312021/0603

Pre-app advice

PRE-APPLICATION ADVICE

Land west of 8 Longridge Road, Hurst Green

Internal Parking Area & Drainage

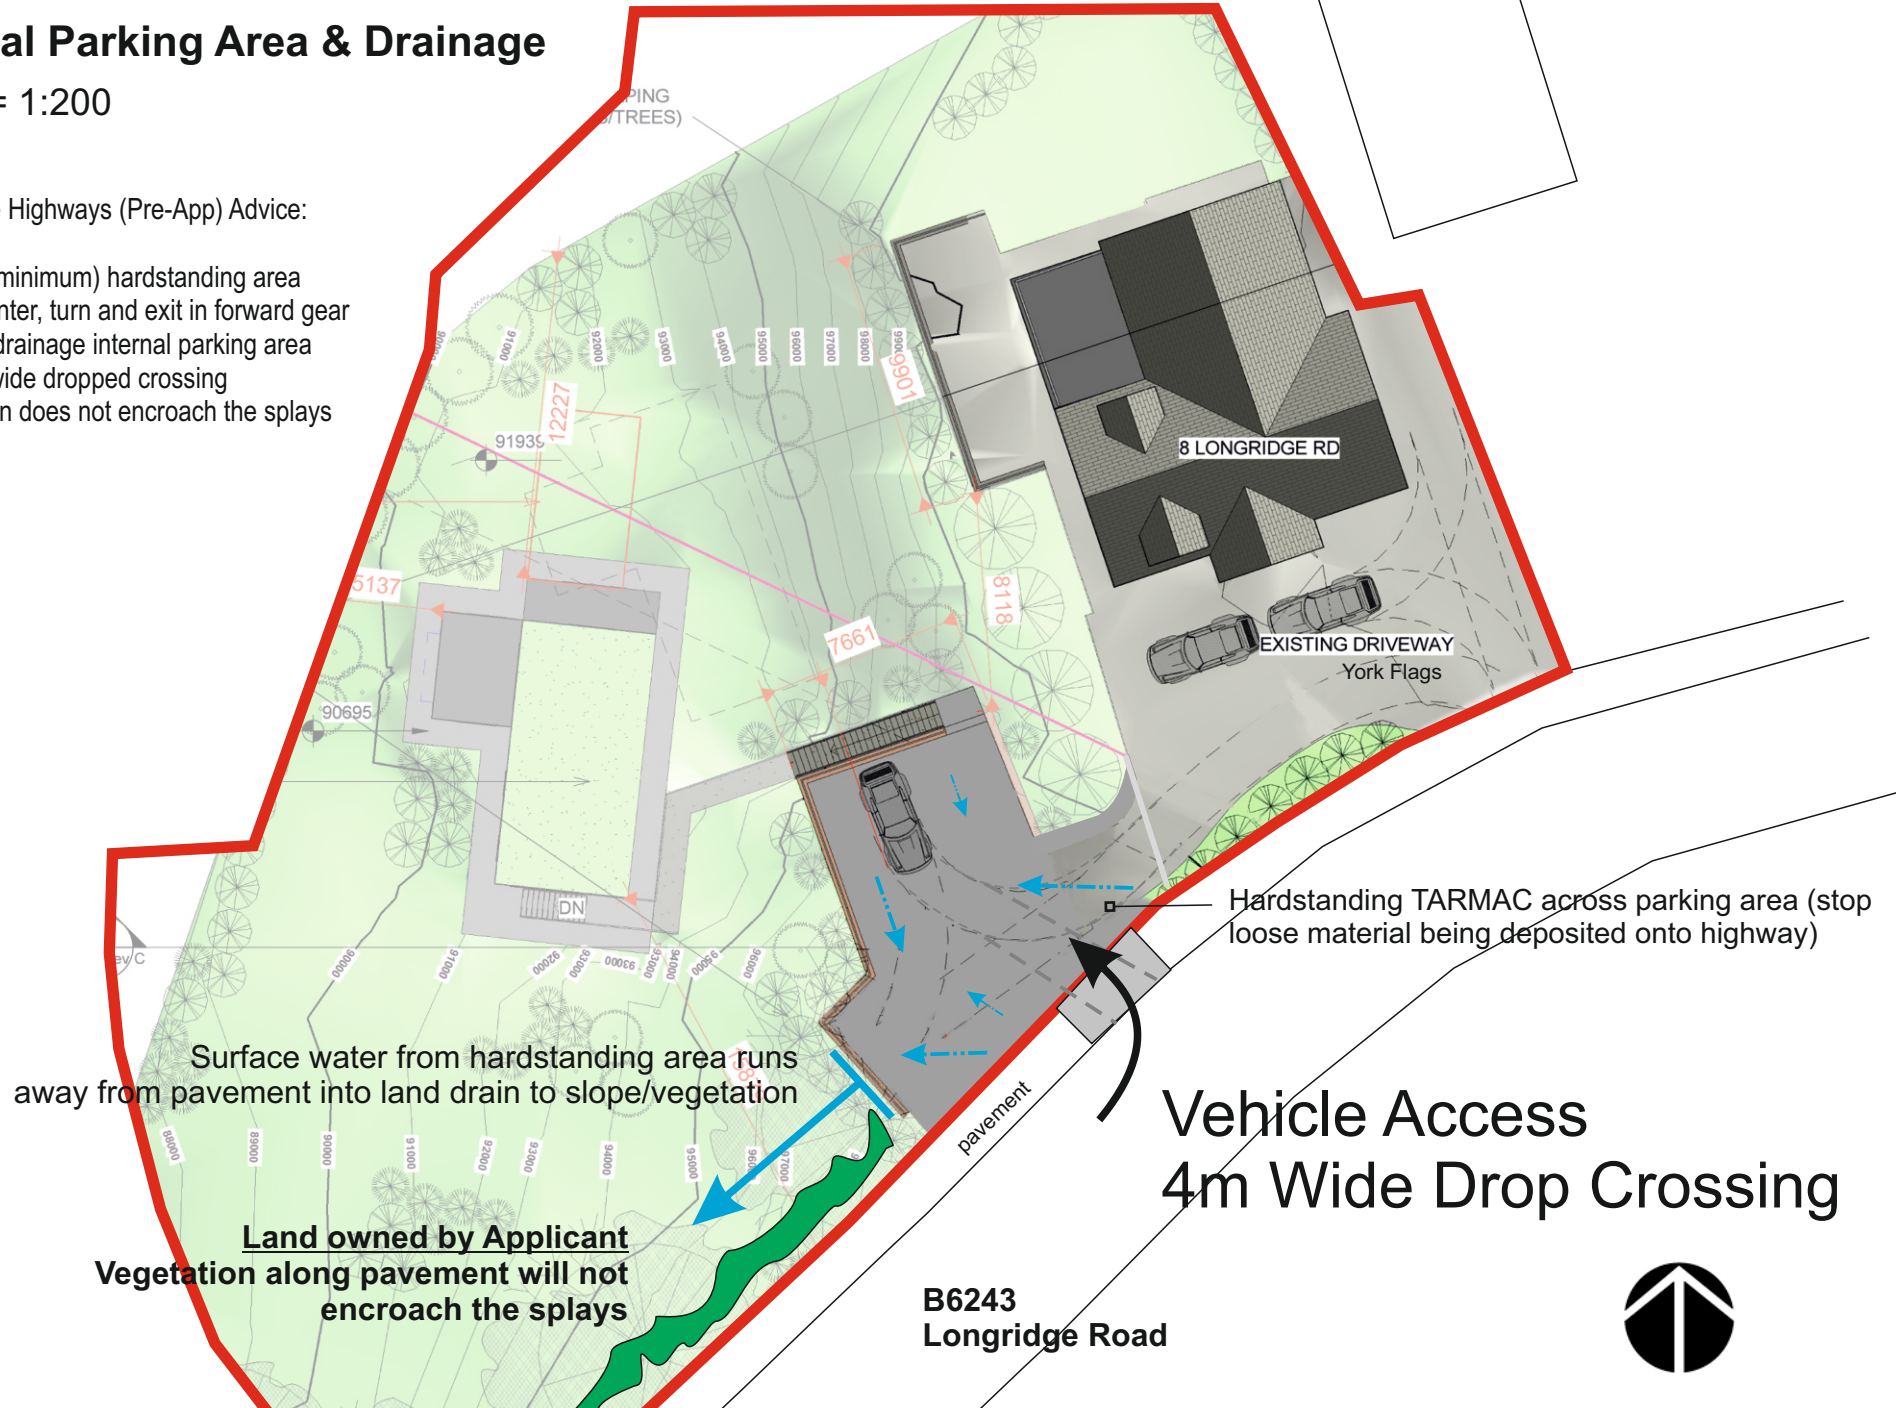
- ✓ On a classified road we would expect the internal area to be sufficient in size to allow a vehicle to enter, turn and exit in forward gear.

- ✓ A scale drawing should be submitted to show the extents of the internal area and it should be surfaced in a bound material for the width of the opening for the first 5m into the site to avoid loose material being deposited onto the highway.
- ✓ No water should flow from the hardstanding to the highway and vice versa and surface water drainage should be provided to prevent capture this.
- ✓ A 3 – 4m opening would be acceptable and any gates would need to be set back from the carriageway by 5m to ensure that a vehicle can clear the carriageway whilst the gates are operated.

The hardstanding would need to be constructed prior to the construction of the dropped crossing.

1. Provide a scale plan showing the visibility splays on Longridge Road. ✓
2. Provide a scale plan showing the extent of the internal parking area. ✓
3. Provide construction and drainage details of the internal parking area. ✓

Scale Plan: Visibility Splays

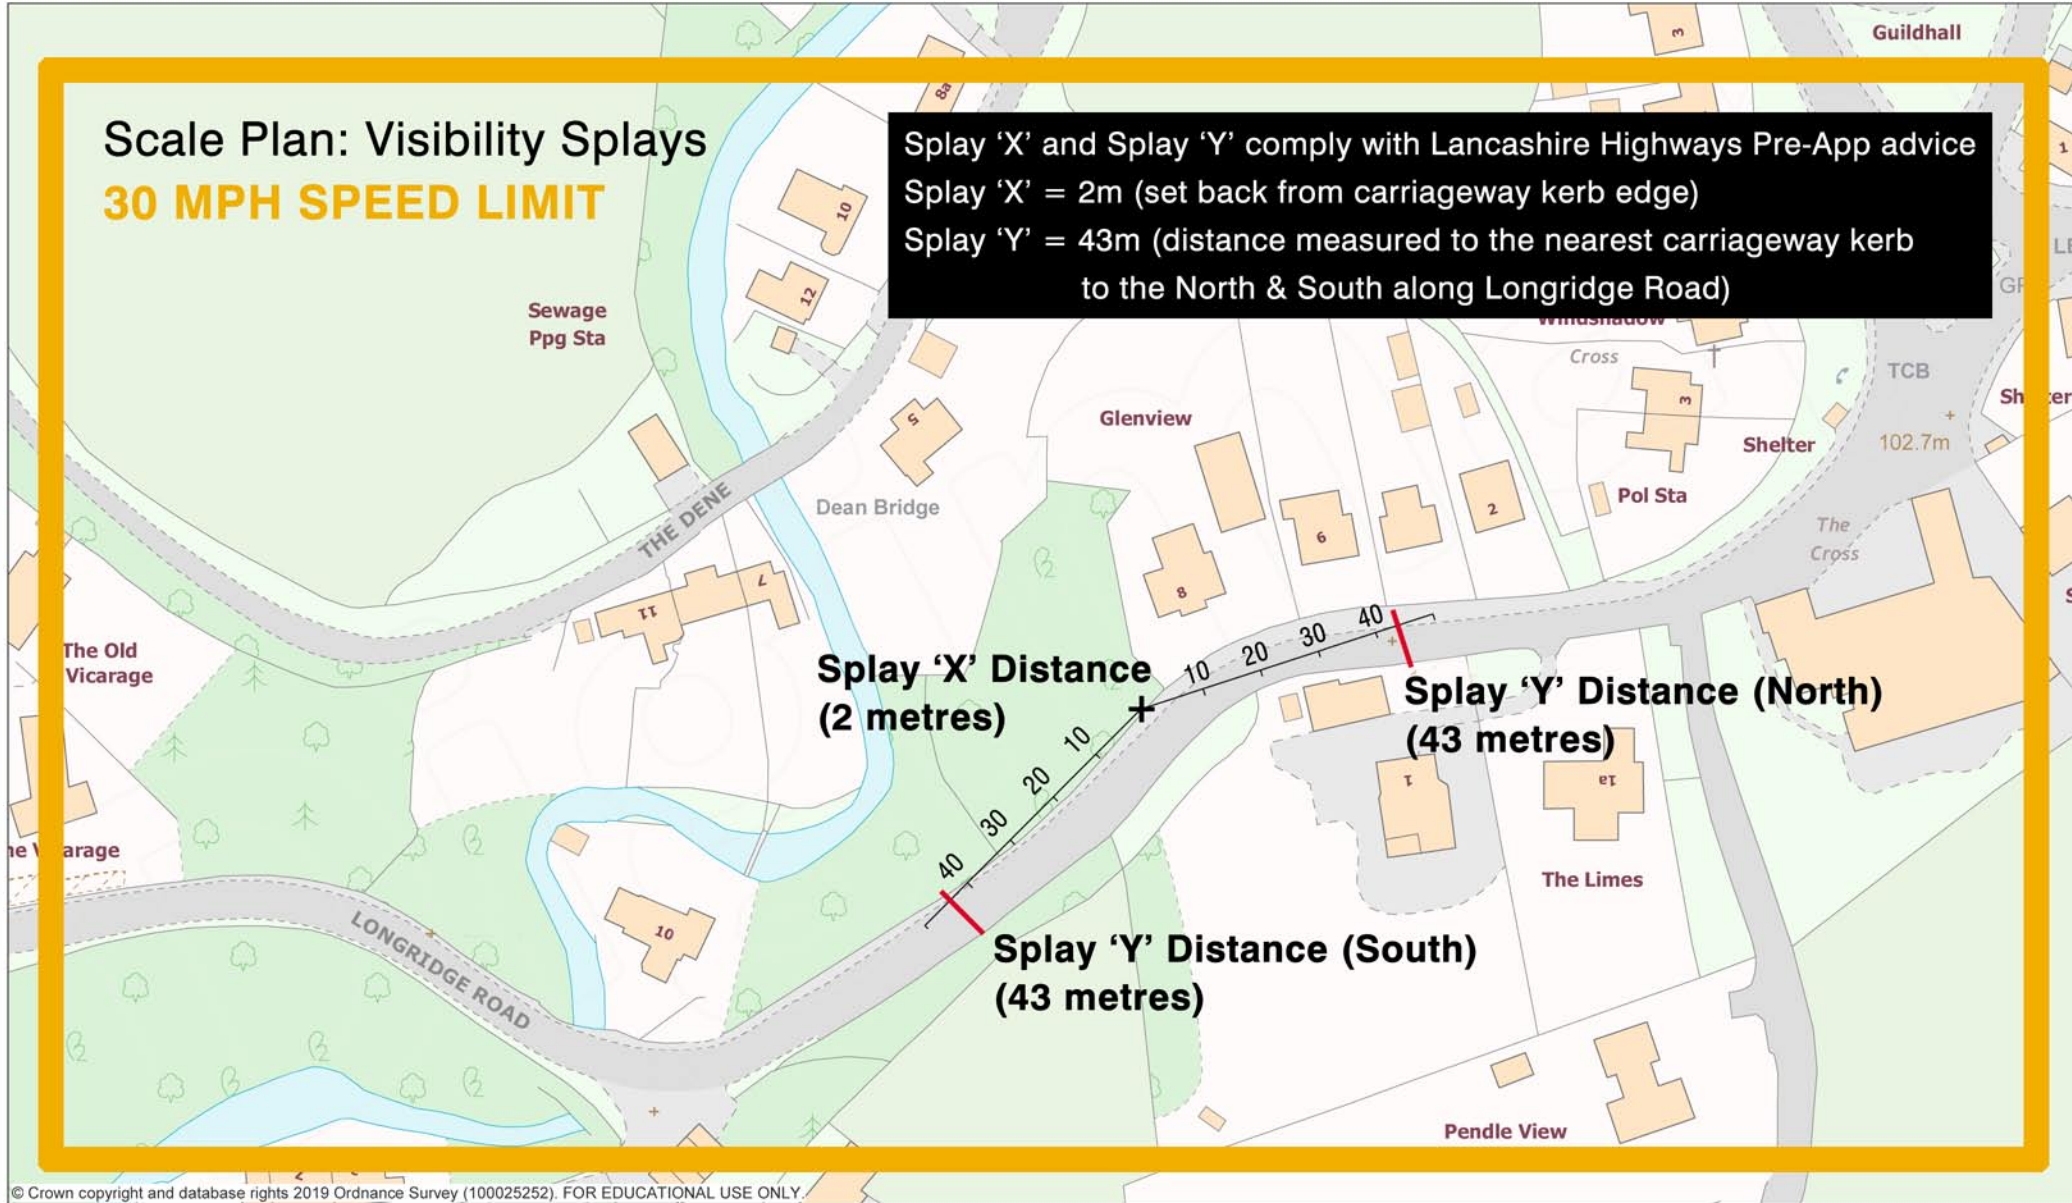
The visibility splays of X2m by Y43m are required in this case. The x distance is the set back from the carriageway kerb edge and the Y distance is measured to the nearside carriageway kerb along Longridge Road. The splay to the north along Longridge Road lies within the adopted highway and the splay to the south along Longridge Road crosses the vegetation along the boundary which appears to be within your control. You will need to submit a scale plan showing the splays and ensure that the vegetation does not encroach the splays.
